Case Officer: Shona King

Proposal: Discharge of Conditions 2 (Schedule of materials), 3 (Samples of slate), 4 (stone sample panel), 6 (doors & windows), 7 (gable dormer details), 8 (ridge architectural details) and 11 (location of bat boxes) of 21/01254/REM

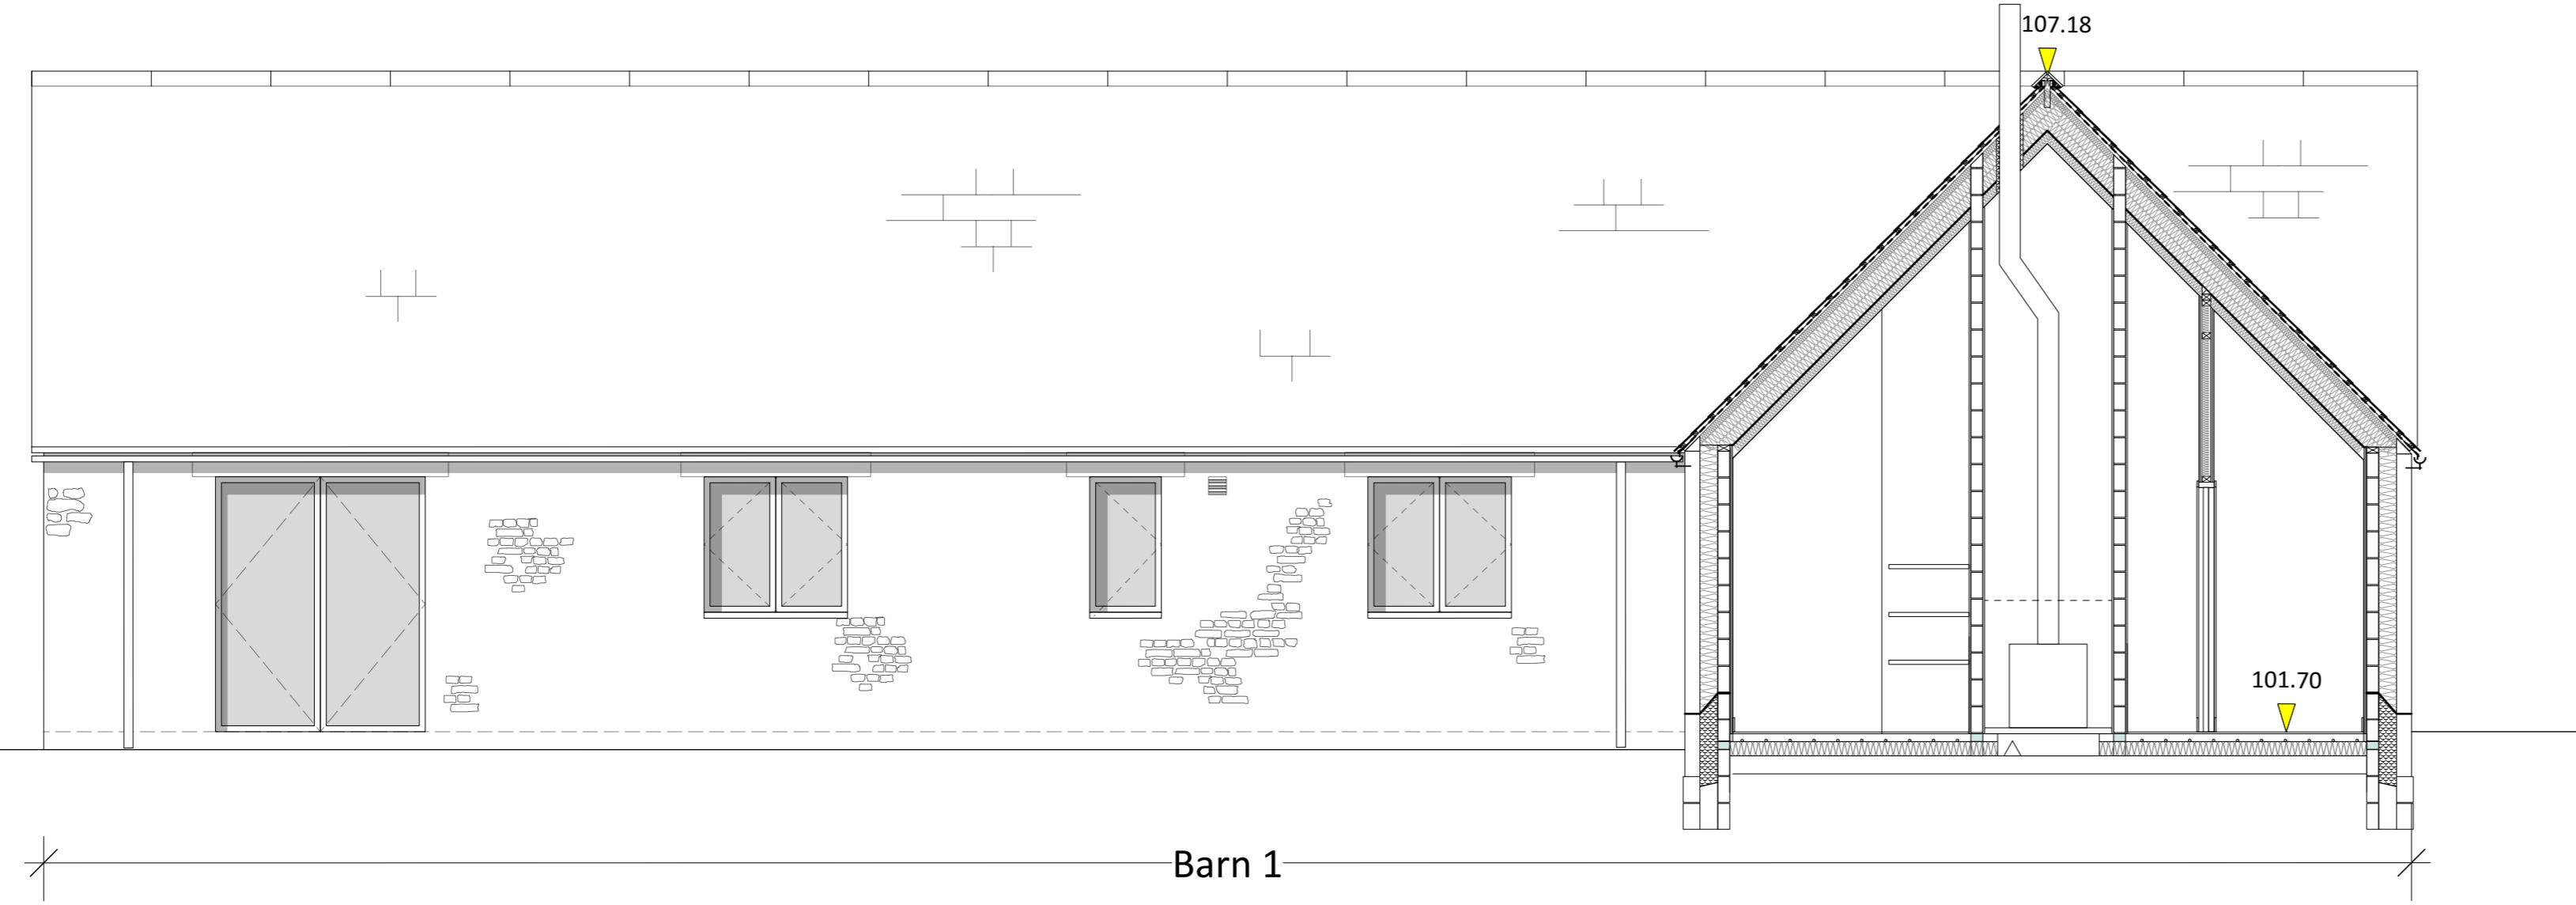
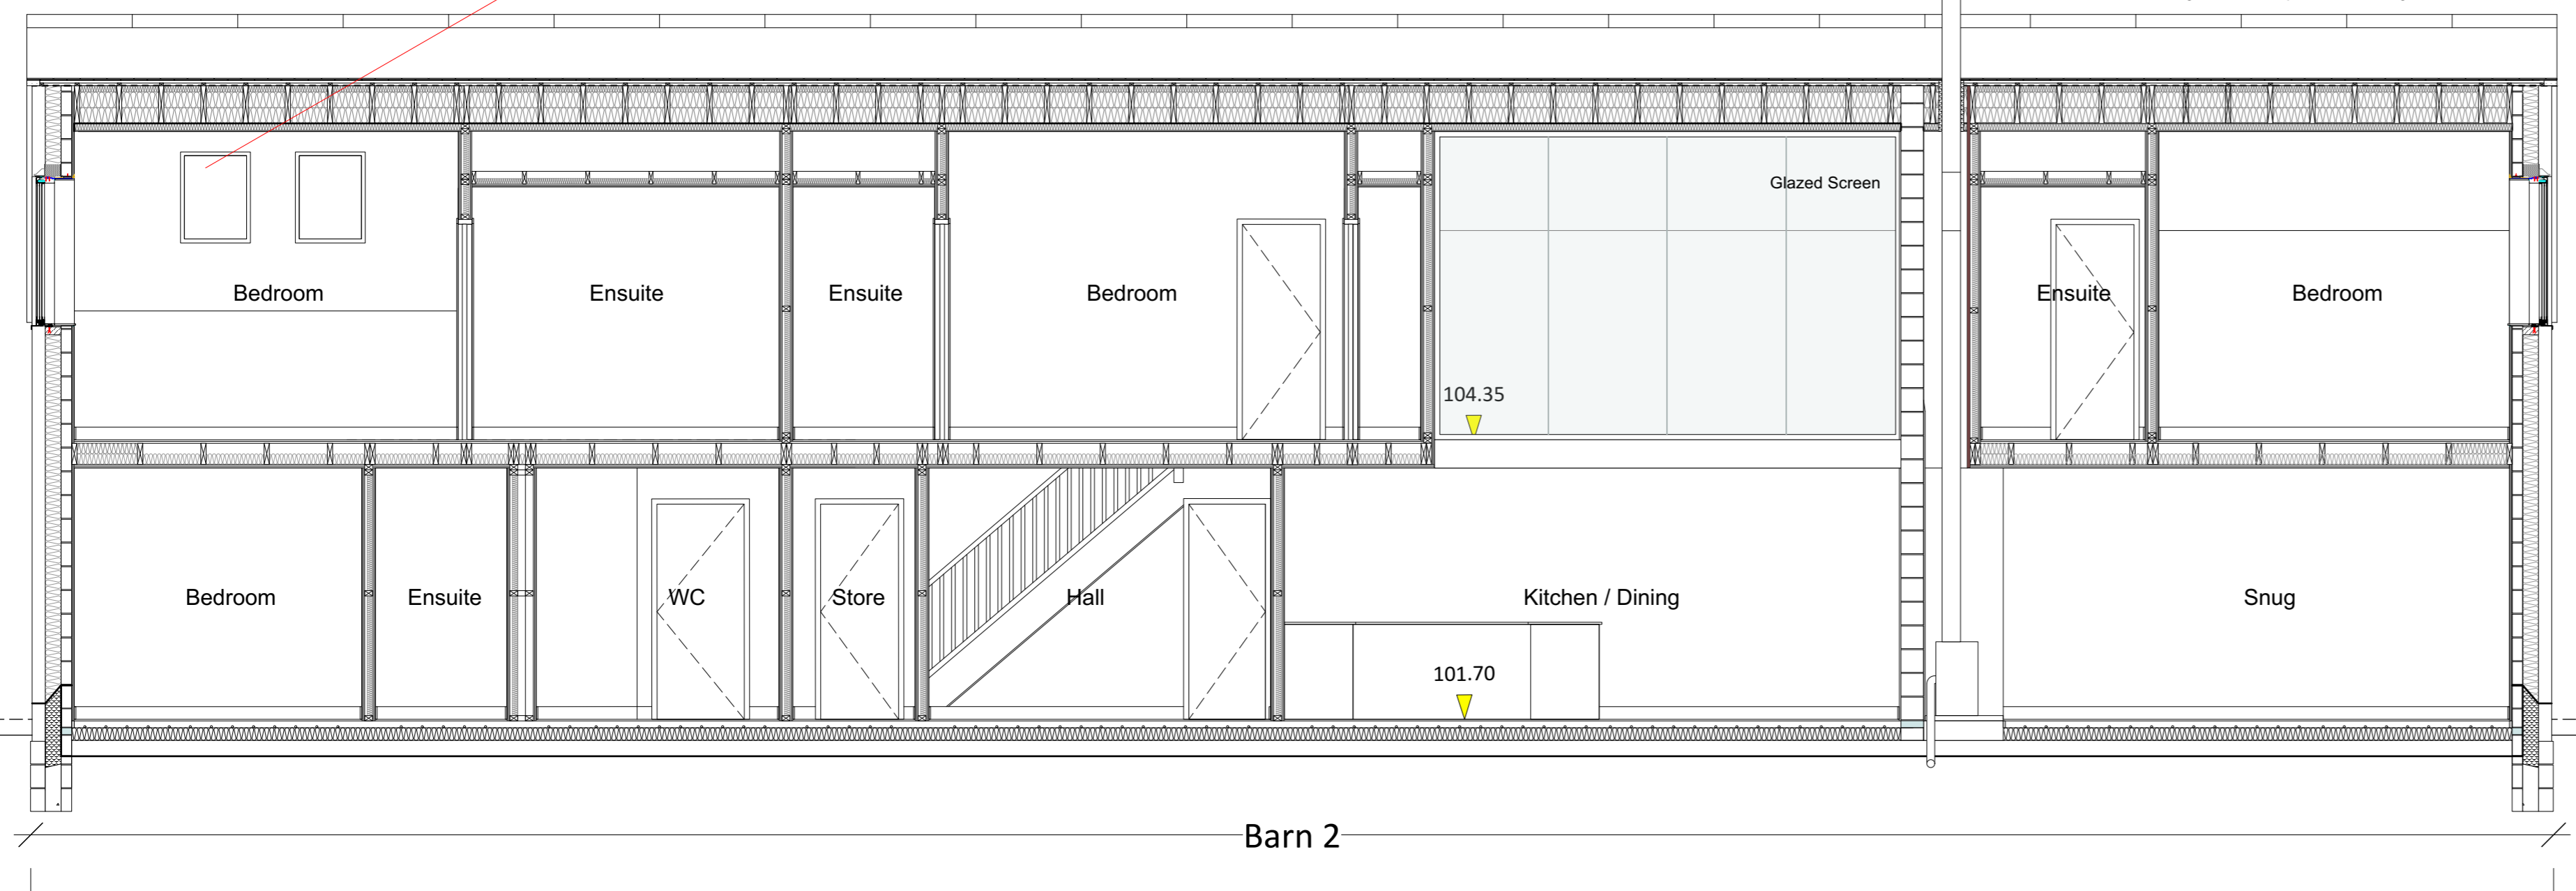
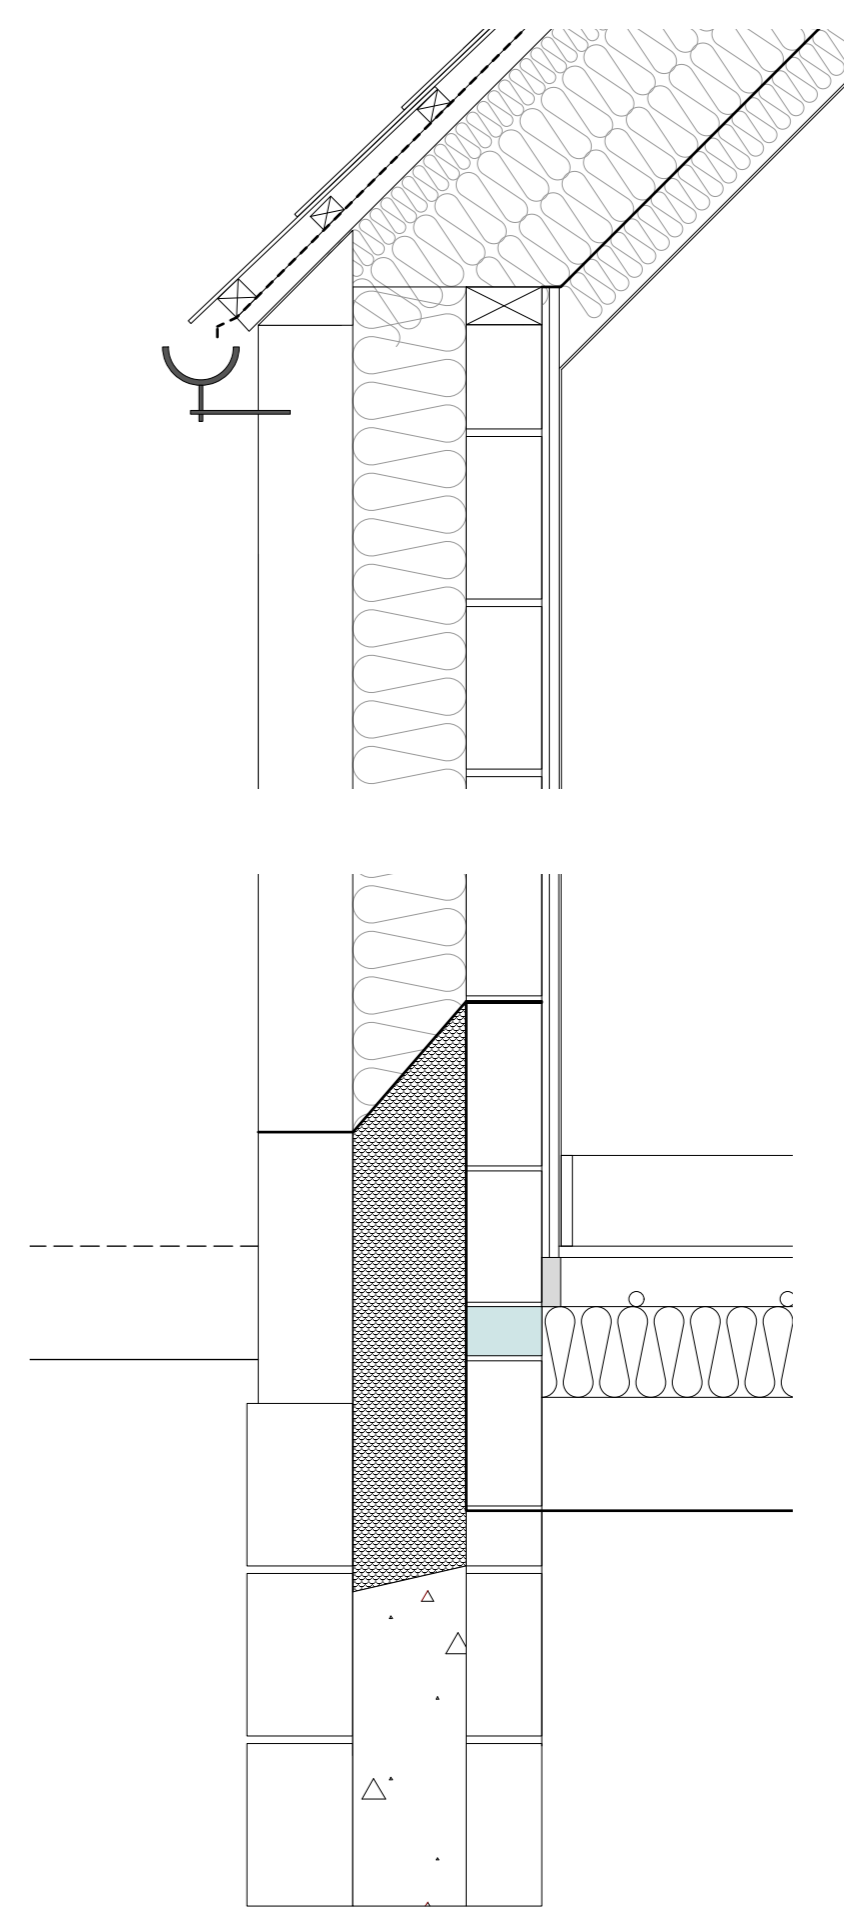
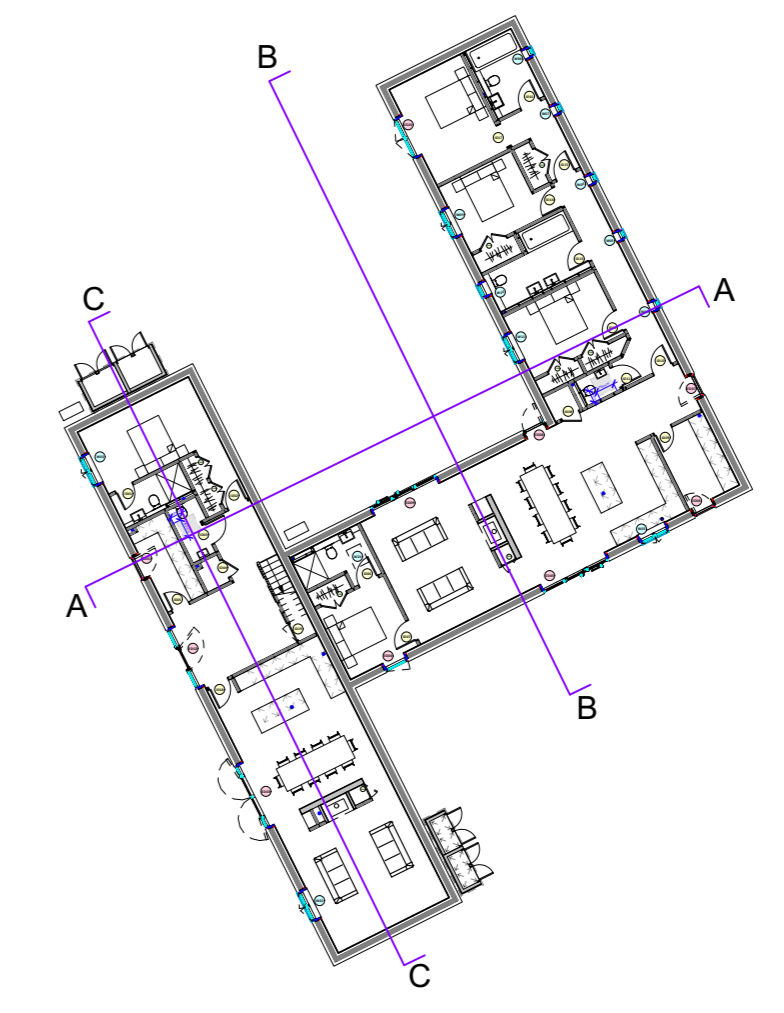
Condition 8

Drawing Nos: 21.02.04.15 and 21.02.04.16

REVISIONS				
PROJECT	Crockwell			
ADDRESS	Crockwell House Farm, Manor Road, Great Bourton, OX17 1QT			
DRAWING NUMBER	21.02.04.24			
	21.02.04.24			
STATUS	Tender			
DRAWN	CHECKED	DATE	SCALE	REVISION
GY	JN	16.06.22

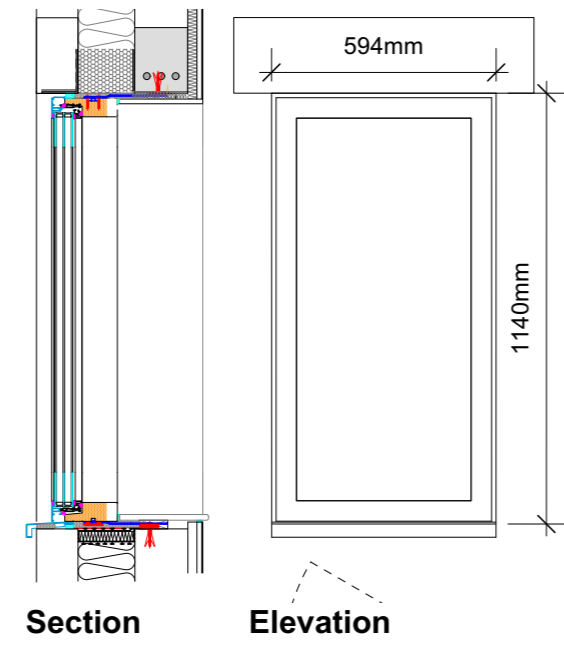
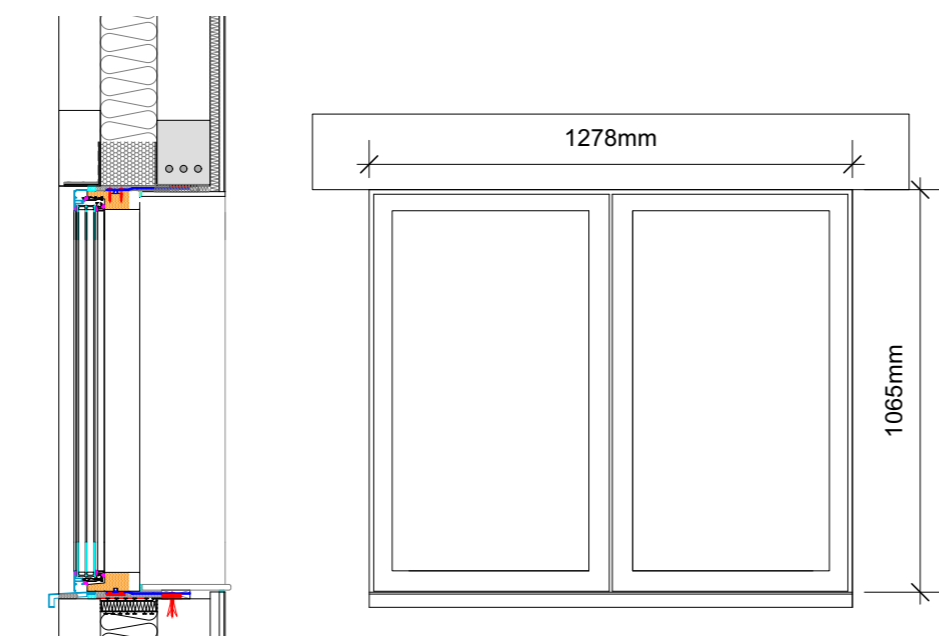
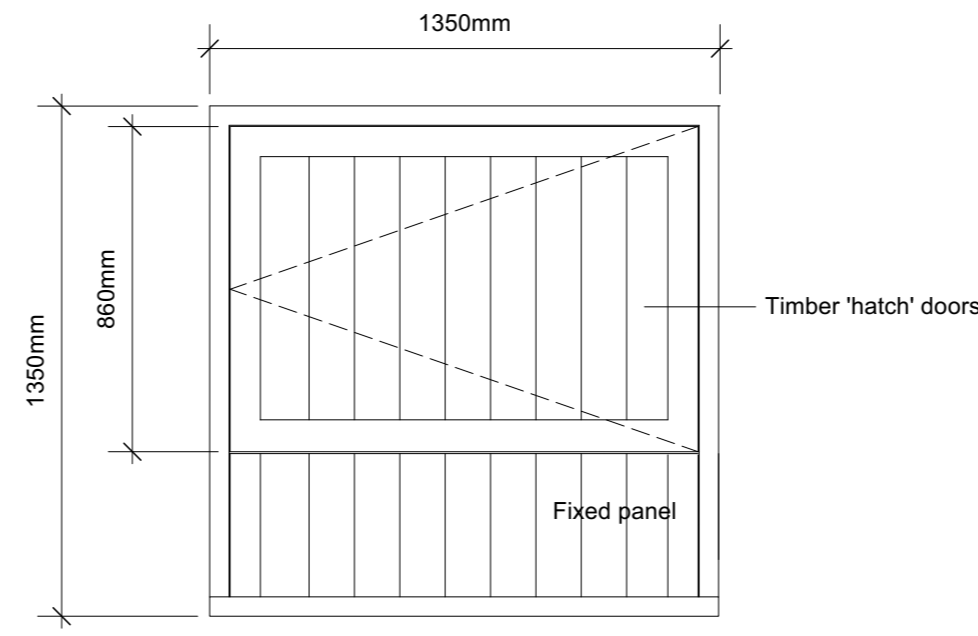
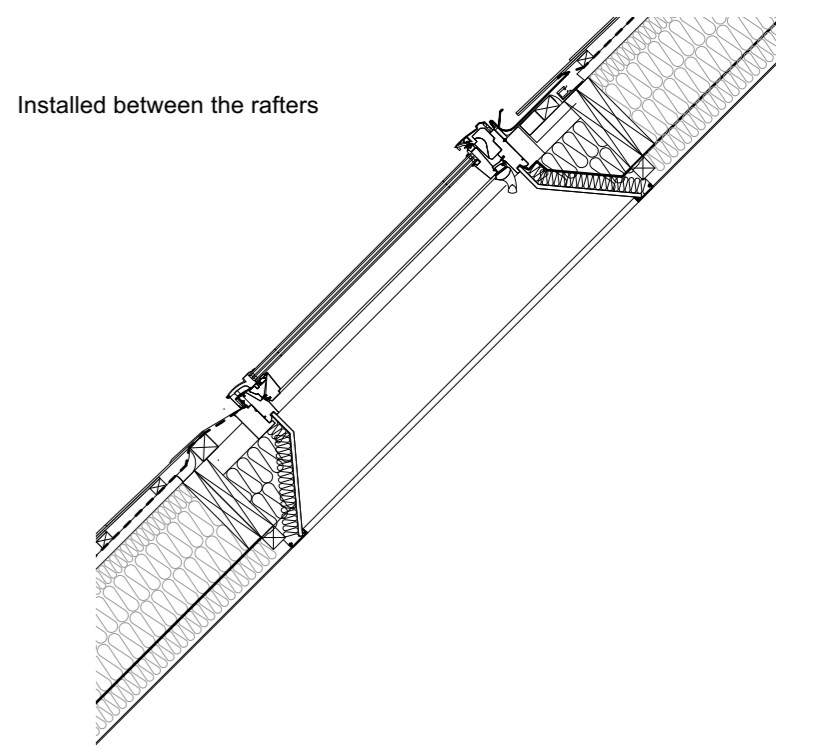
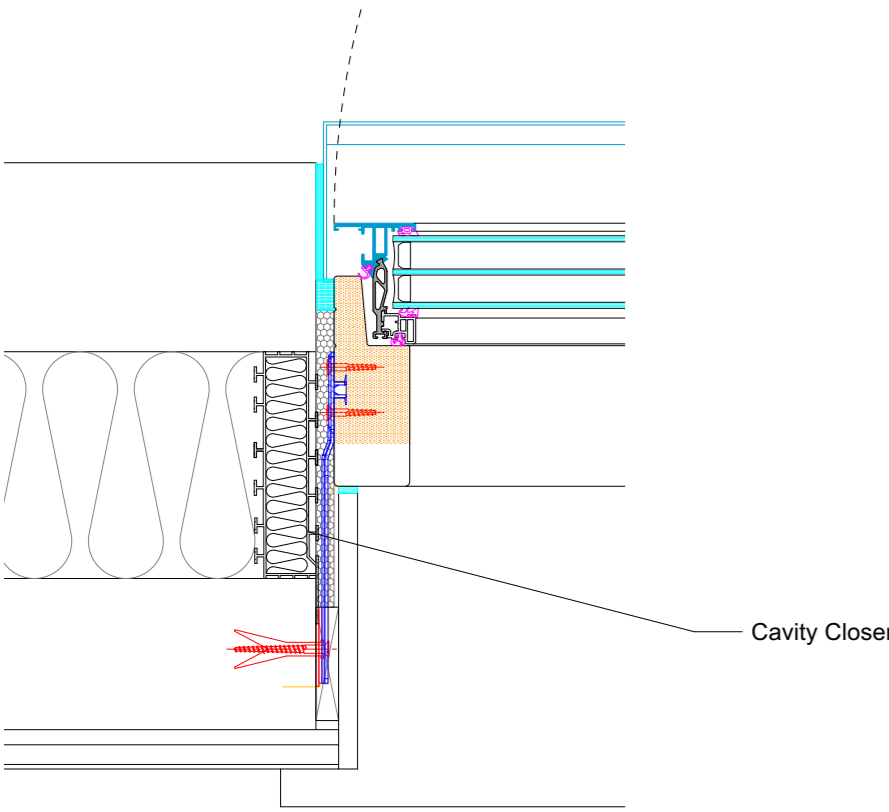
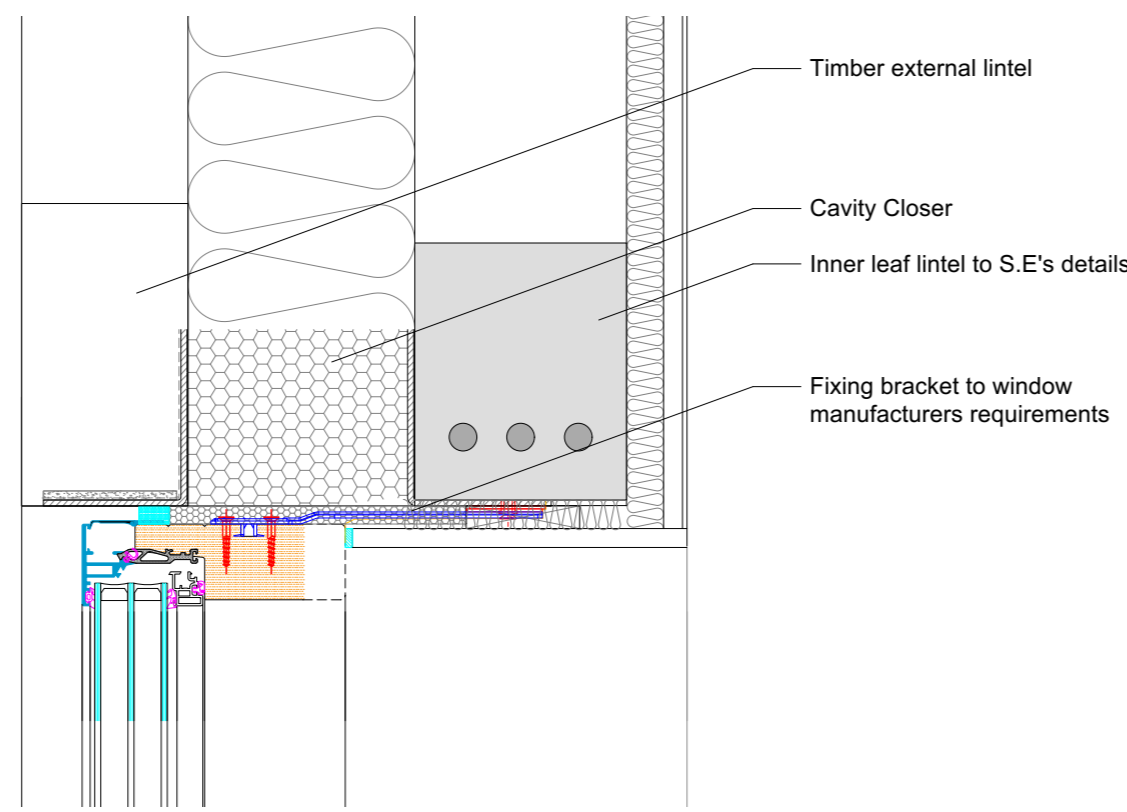
- 5.4. Condition 6 requires the approval of details of the doors and windows. The details that have been submitted are considered to be acceptable.
- 5.5. Condition 7 requires the approval of details of the gabled dormer. The details that have been submitted are considered to be acceptable.
- 5.6. Condition 8 requires the approval of the architectural detailing of the ridge and treatment of the eaves and verges. The details that have been submitted are considered to be acceptable.
- 5.7. Condition 11 requires the approval of a scheme for the location of bat boxes. The proposed bat boxes are suitable for the species found foraging and roosting and should constitute an enhancement in opportunities on site.

Condition 6

Drawing Nos: 21.02.04.22, 21.02.04.23 and 21.02.04.24
